# CITY OF ALBUQUERQUE

December 21, 2020

RE: **Mesa Del Sol International School**  
**Bobby Foster and Newhall**  
**Grading Plan Stamp Date: 11/9/20**  
**Hydrology File: R16D099**

Based on the submittal received on 11/18/20, the Grading and Drainage Plan cannot be approved until the following are corrected:

Overall Grading Plan

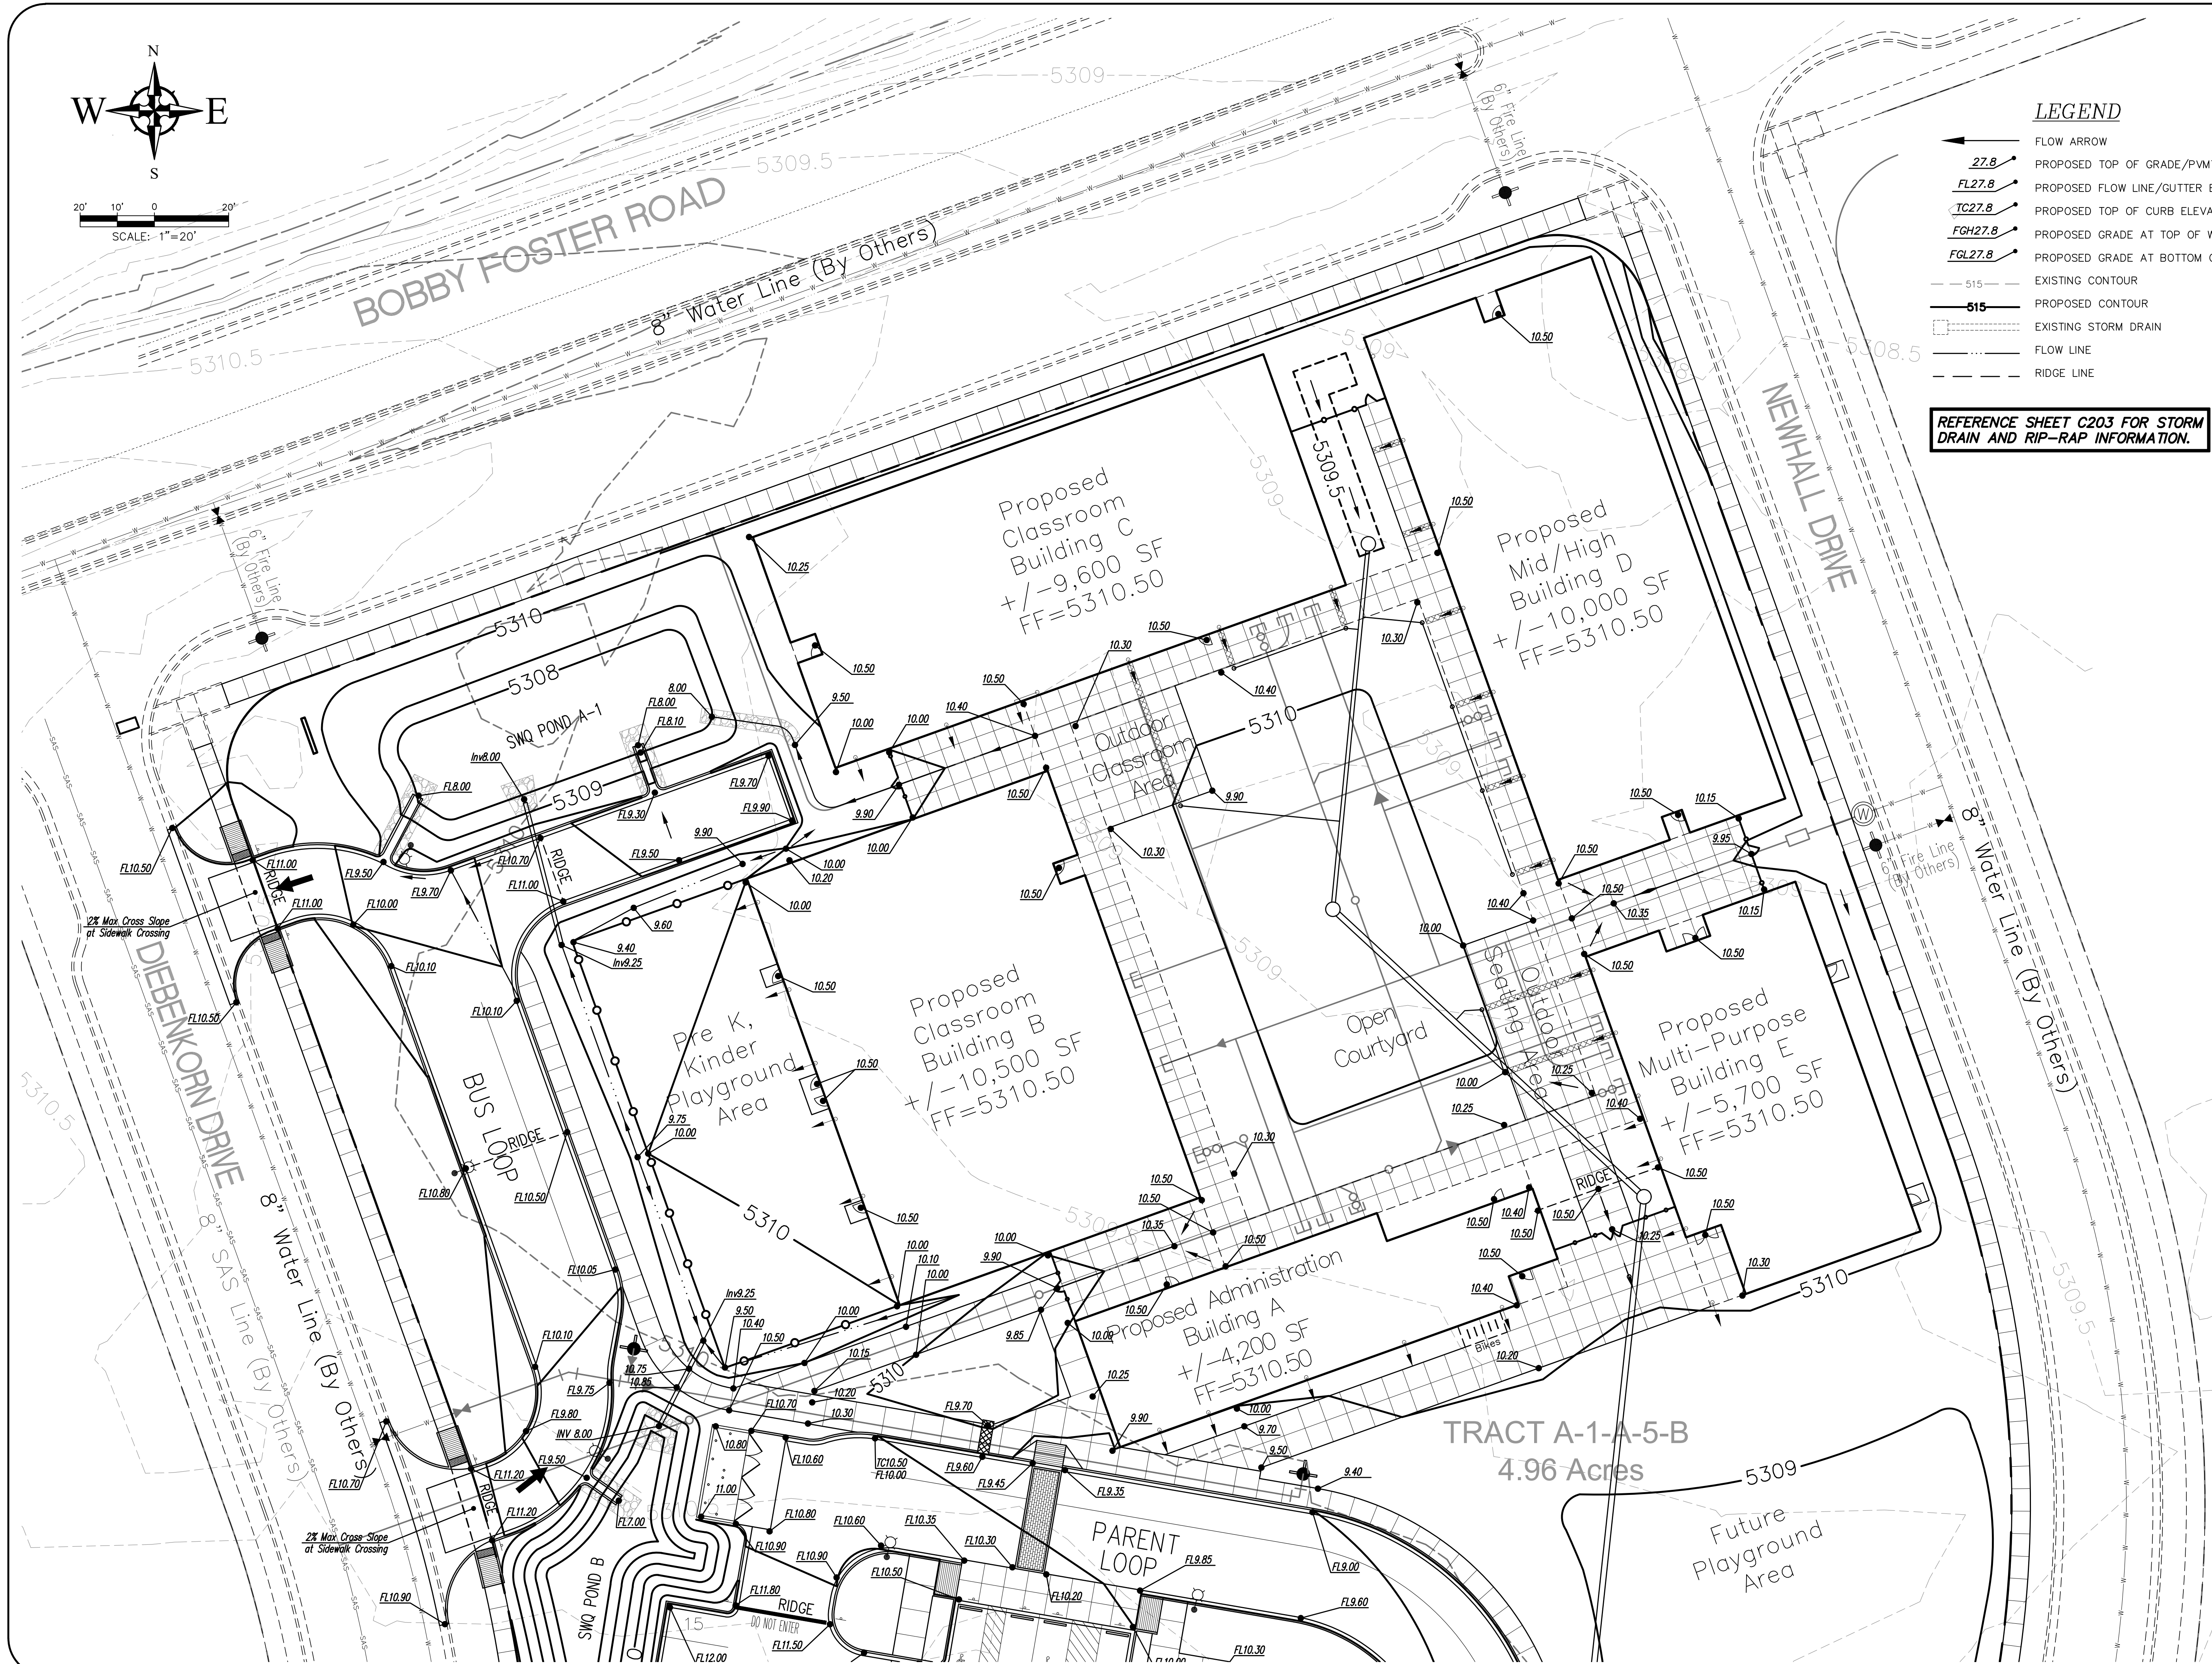
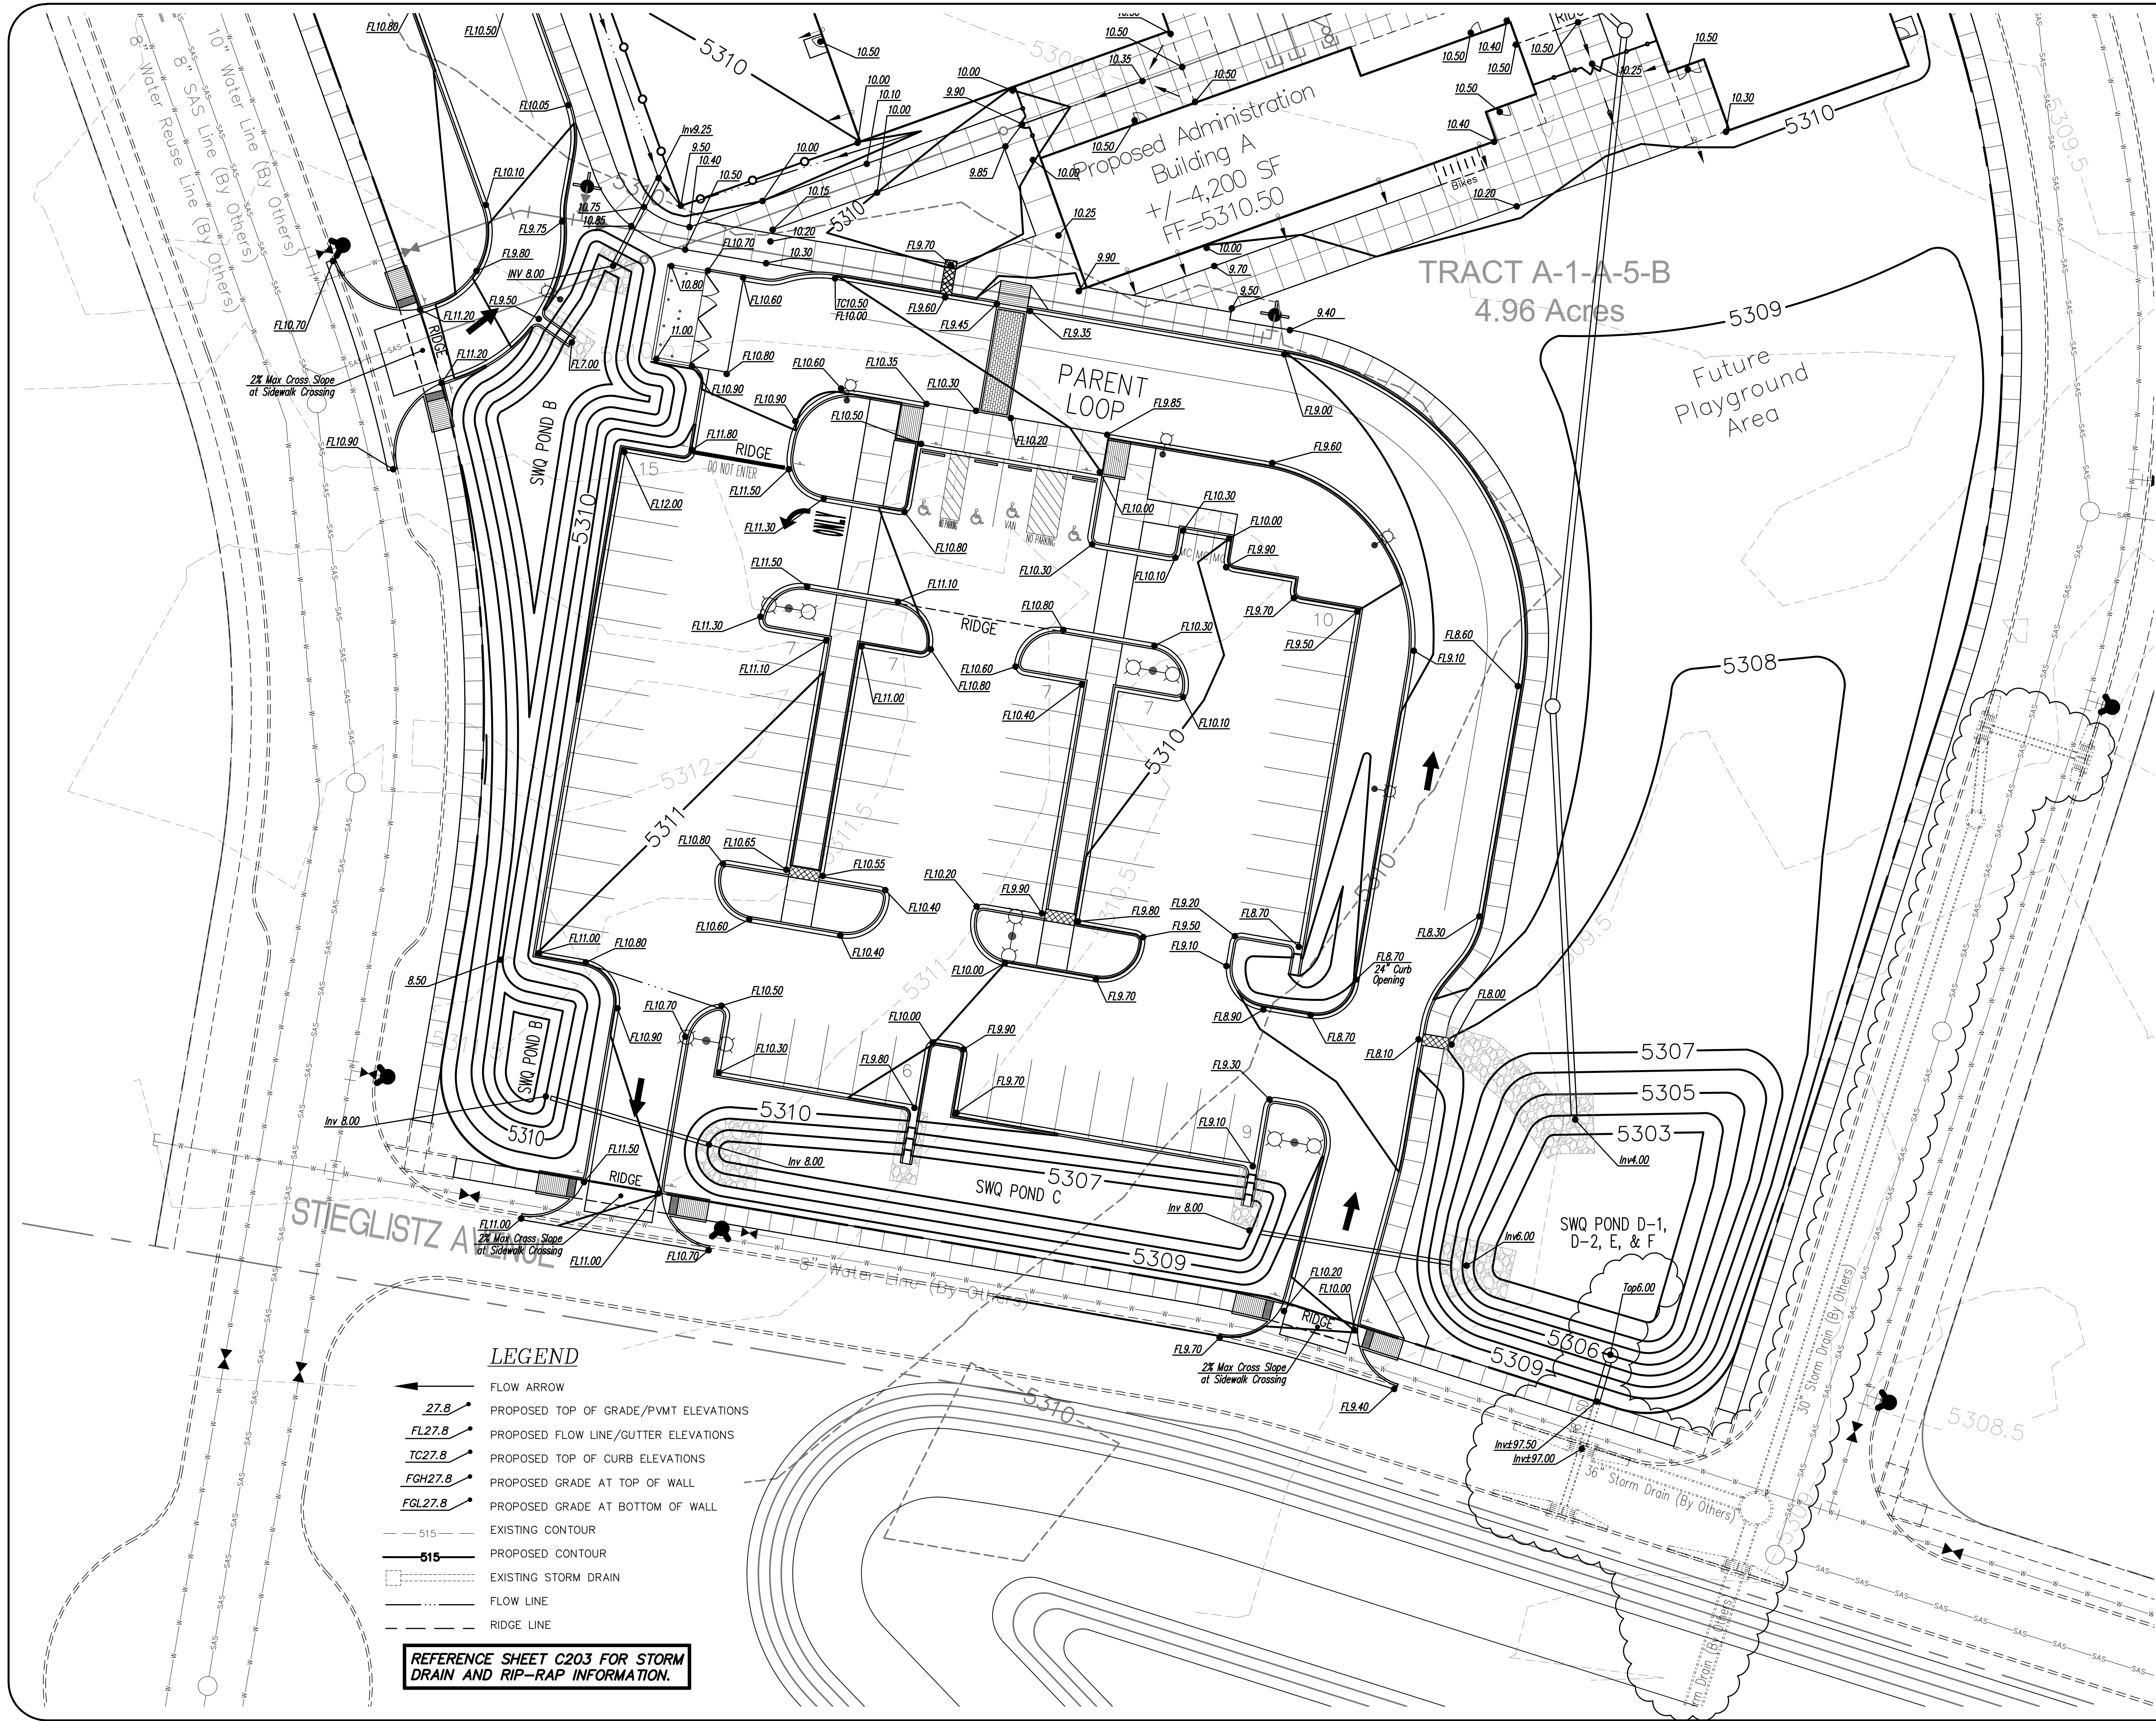
1. On the Proposed Drainage Management Plan sheet please label the ponds on the drawing and list the values for the C and I used in the rational method equation used.

2. The table for Post Development Drainage Calculation stated that it is based on DPM Section 22.2. This should be DPM Chapter 6.2. If the old DPM was used please update all calculation based on the new DPM. If this is just a mislabeling please correct.

International School at Mesa Del Sol
Bobby Foster Rd SE
Albuquerque, NM 87106
Storm Drain Plan

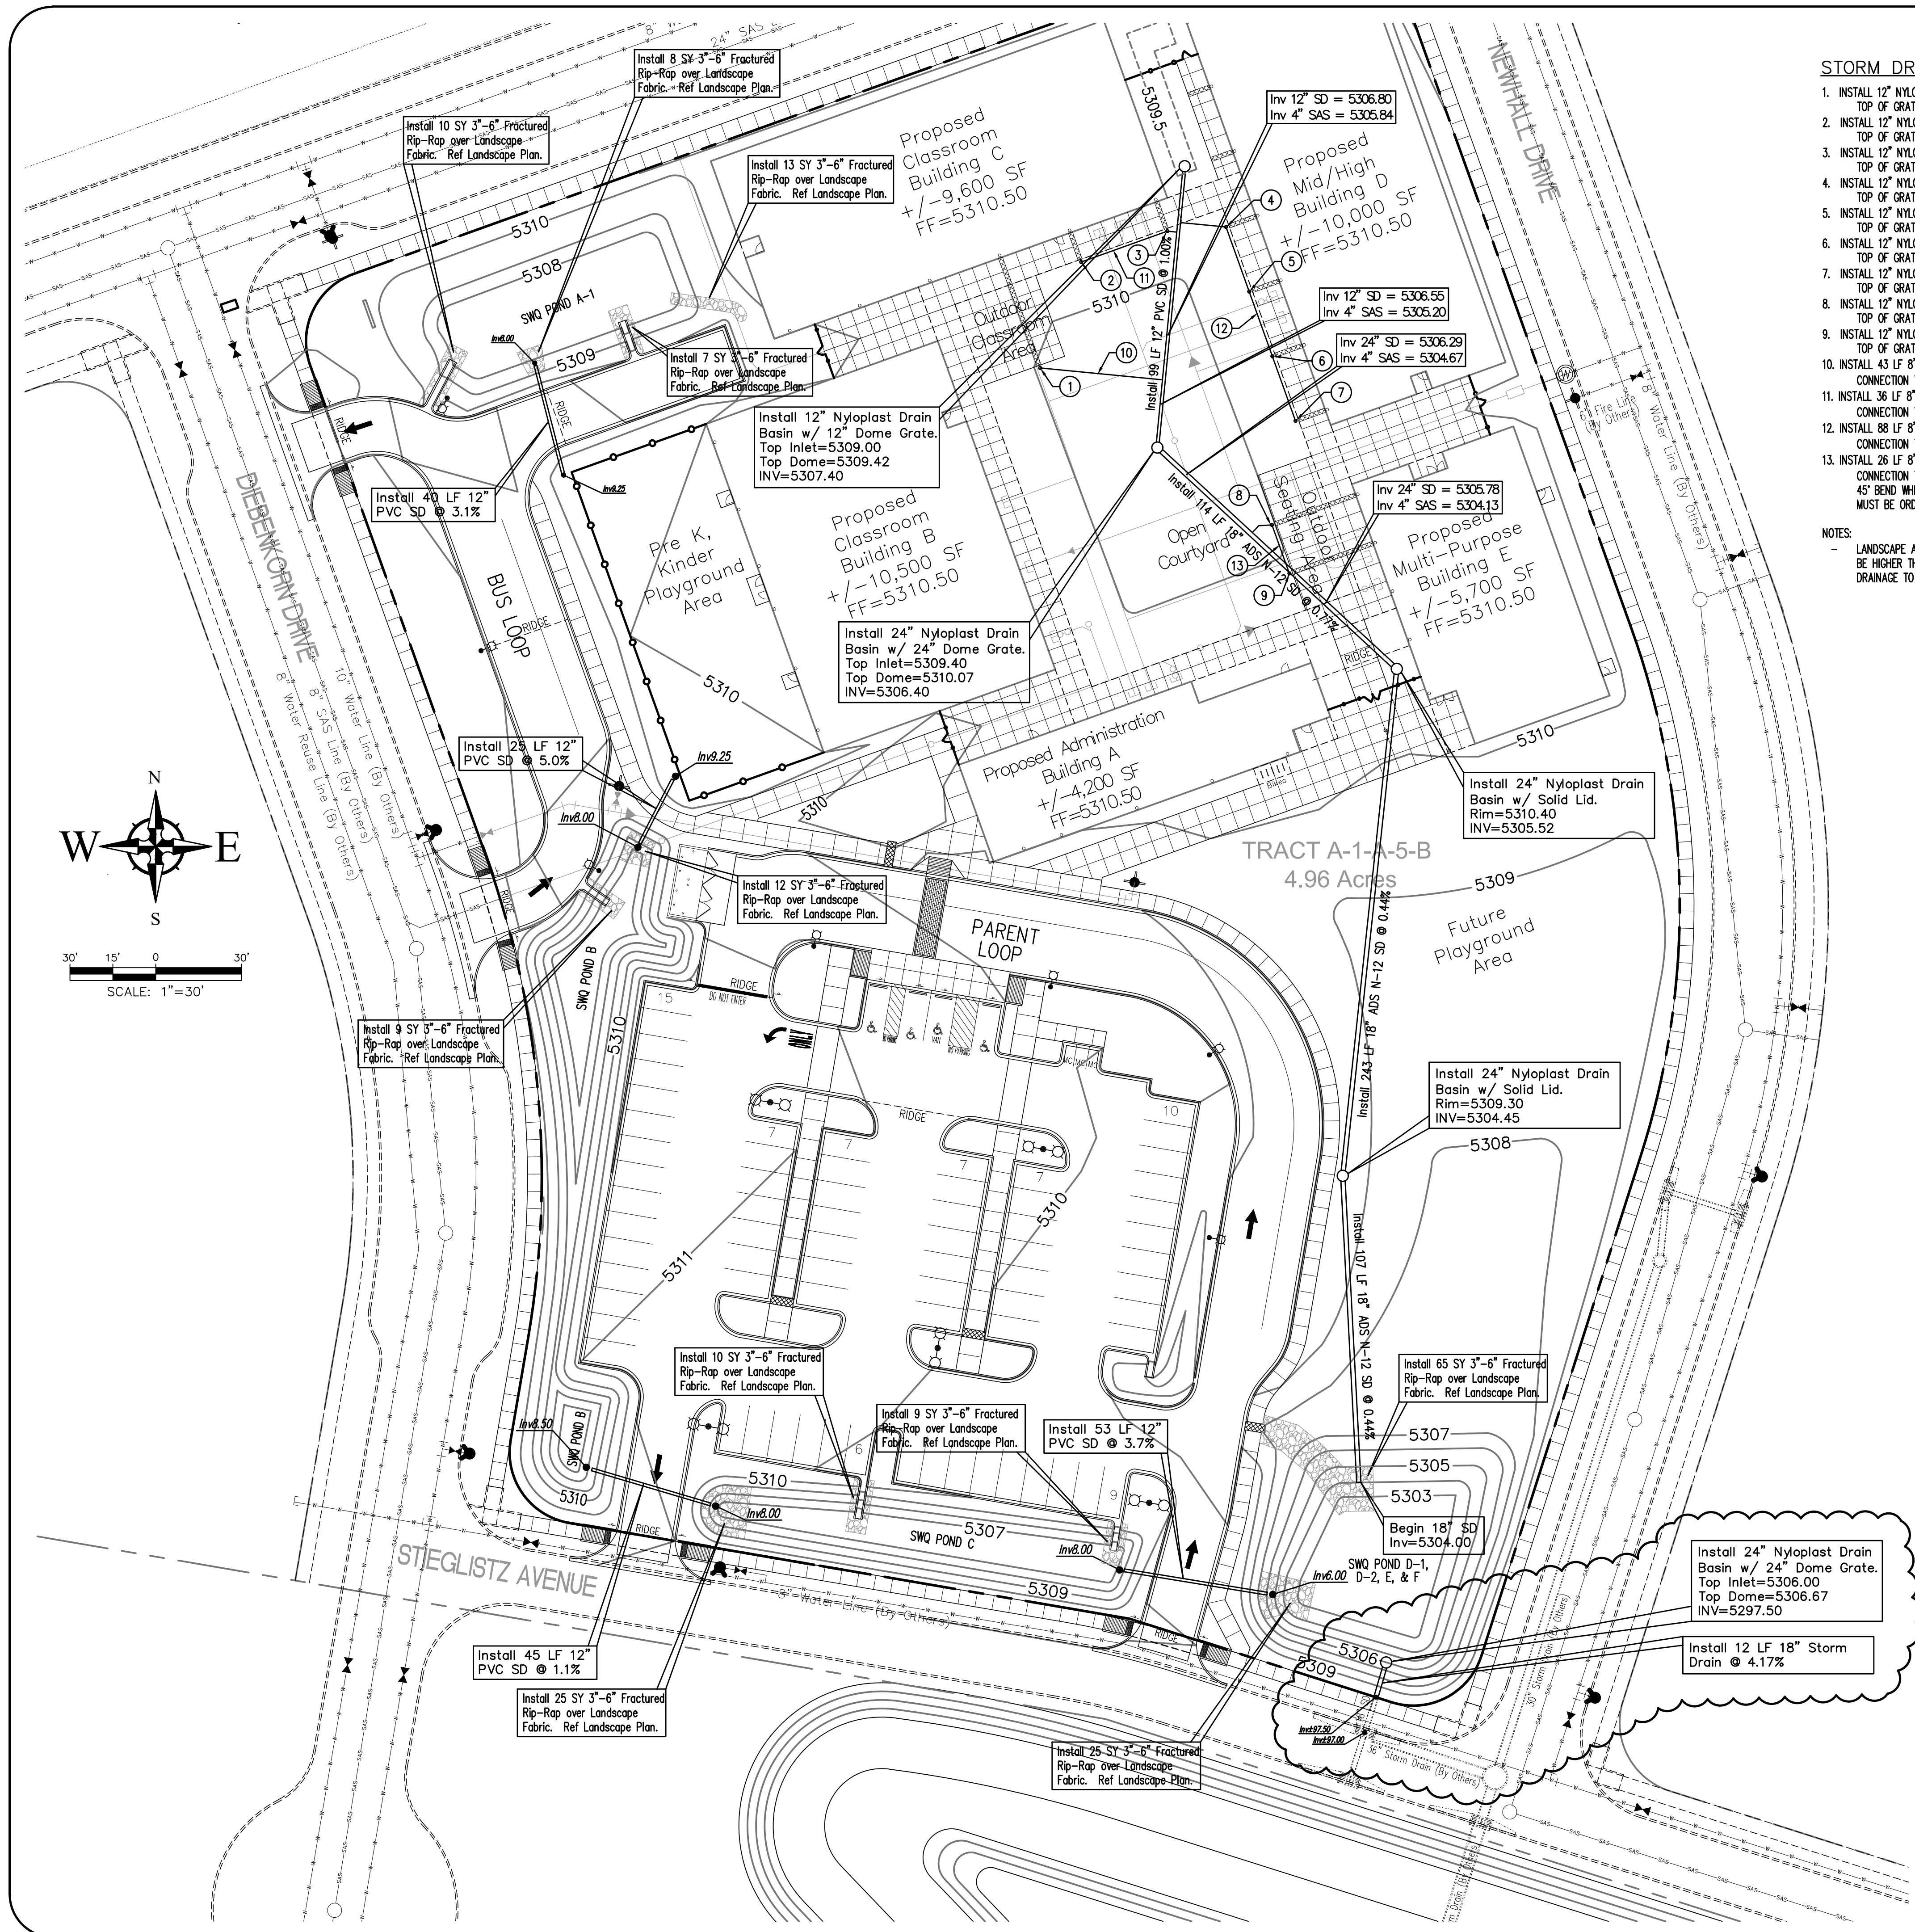
3. Please show calculations for the storm drainpipes to show they can carry flows.
4. In the Introduction on C-204 remove the ??? as the place holder for an address. There is adequate description in the body of the text to locate this site. You may also want to remove this from the title block unless you will be getting an address prior to approval of this sheet.

5. Please provide the details of the rip-rap rundowns and inlets.
6. As a reminder, if the project total area of disturbance (including the staging area and any work within the adjacent Right-of-Way) is 1 acre or more, then an Erosion and Sediment Control (ESC) Plan and Owner's certified Notice of Intent (NOI) is required to be submitted to the Stormwater Quality Engineer (Doug Hughes, PE, [jhughes@cabq.gov](mailto:jhughes@cabq.gov), 924-3420) 14 days prior to any earth disturbance.
